**Howlong Sand and Gravel Quarry Expansion (SSD 8804)  
Advice on EIS**

Liz Rogers  
Manager, Assessments  
**Water – Strategic Relations**  
25 June 2020

## Detailed advice to DPIE Planning & Assessment regarding the Howlong Sand and Gravel Quarry Expansion (SSD 8804) EIS

**FIGURE 1-3 SITE LAYOUT**

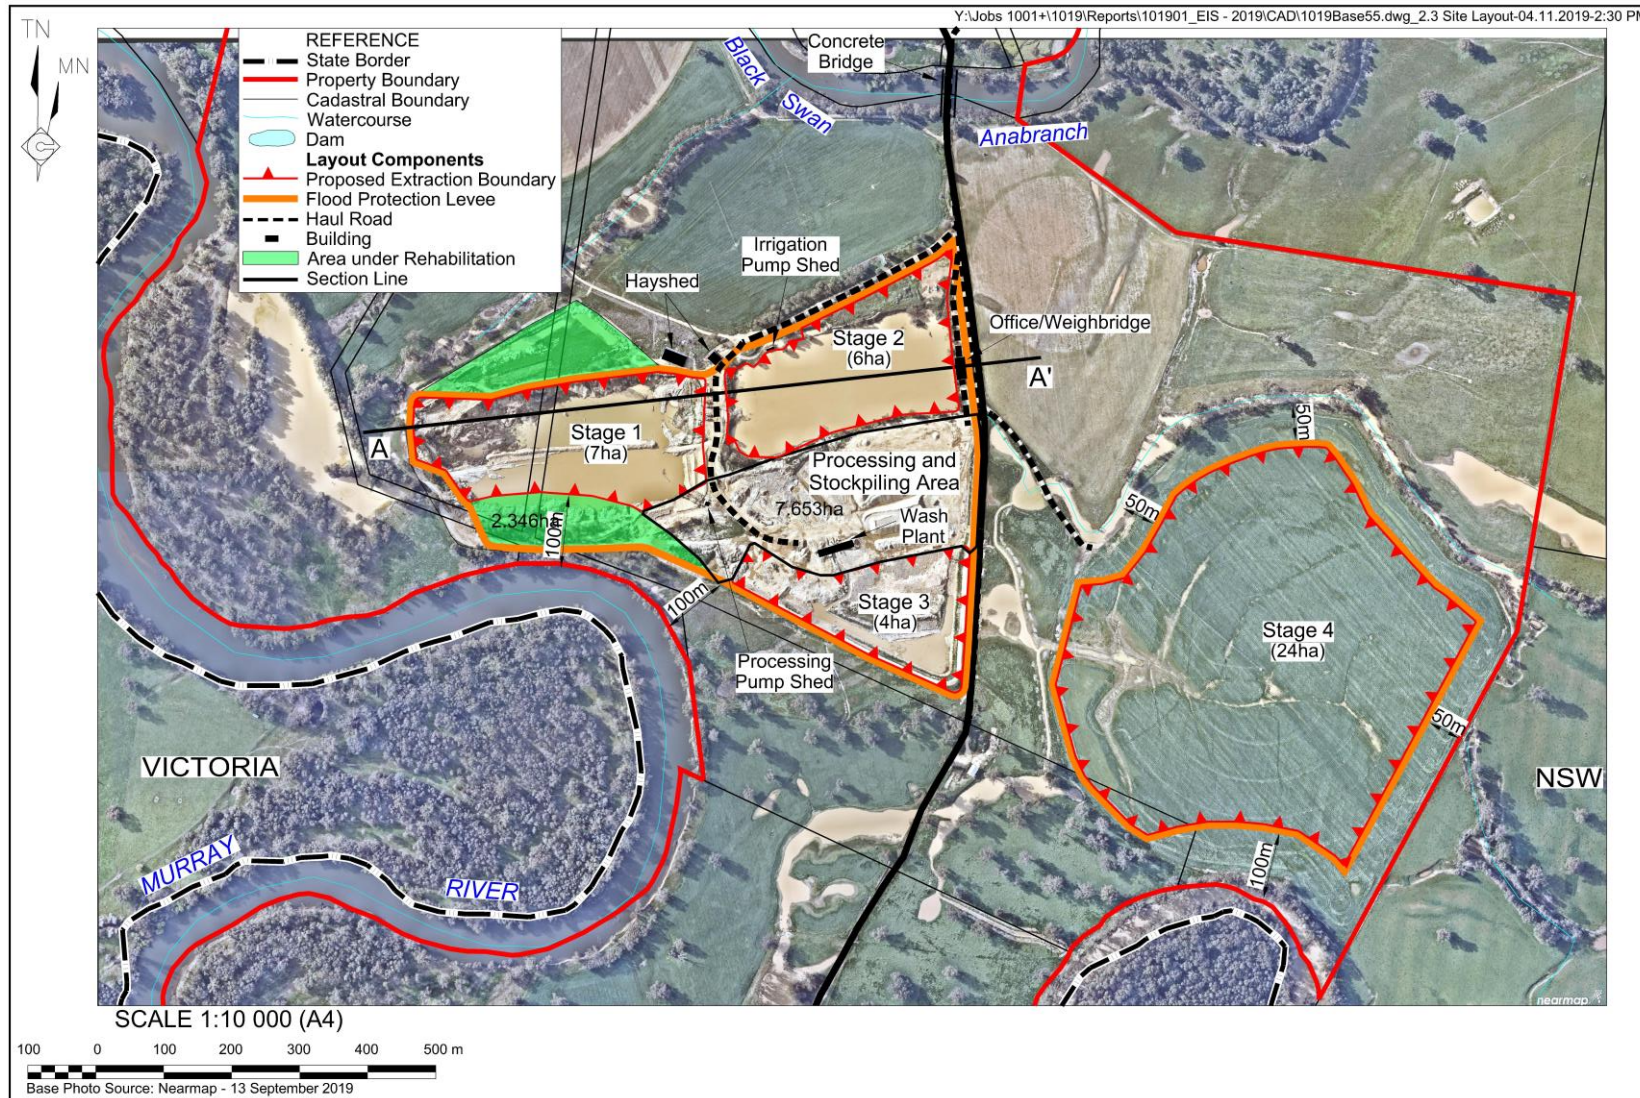
- **Realign the levee at the location of the proposed 100m buffer to adjacent to the Stage 1 excavation area.**

The proposed reinstatement of a 100m buffer between the river and the Stage 1 excavation area is supported. This can minimise the risk of the river connecting with the excavation area in the event the levee is destabilised. Based on the levee location depicted in the EIS it appears the levee will be within approximately 20m of the river bank. The levee will therefore continue to interfere with river floodplain connectivity and riparian functioning. To achieve the riparian and floodplain benefits of a buffer it is recommended the levee be aligned adjacent to the proposed Stage 1 extraction area.

**FIGURE 5-1 REVISED LEVEE ALIGNMENT AROUND EXTRACTION PITS**

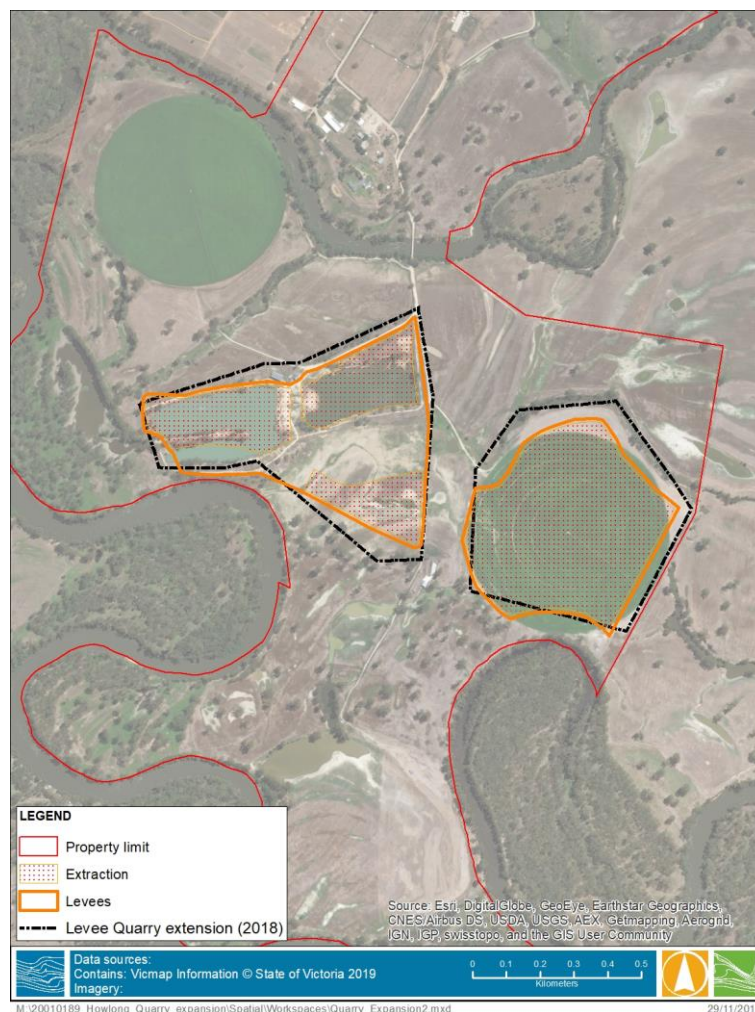
- **Clarify the potential for increased erosion risk to the floodplain and/or the Murray River due to changes to flooding characteristics because of the proposed levees.**

Insufficient information has been provided to understand the potential for increased erosion risk to the floodplain or the Murray River due to the proposal. The flood assessment is limited to flood heights and flood extent and has not included flow velocity or shear stress.

- **Clarify the risk to floodplain and pit stability due to floodplain flows if the levees are removed to address water quality issues in the pits post closure.**

The proponent has proposed to remove the levees post closure if irrigation ceases to perform as a water quality management function for water retained in the pits. The removal of the levees raises the risk of floodplain flows having an impact on the stability of the pit walls and the adjacent floodplain. The proponent should provide an assessment of impacts and any necessary mitigation measures for the removal of the levees.
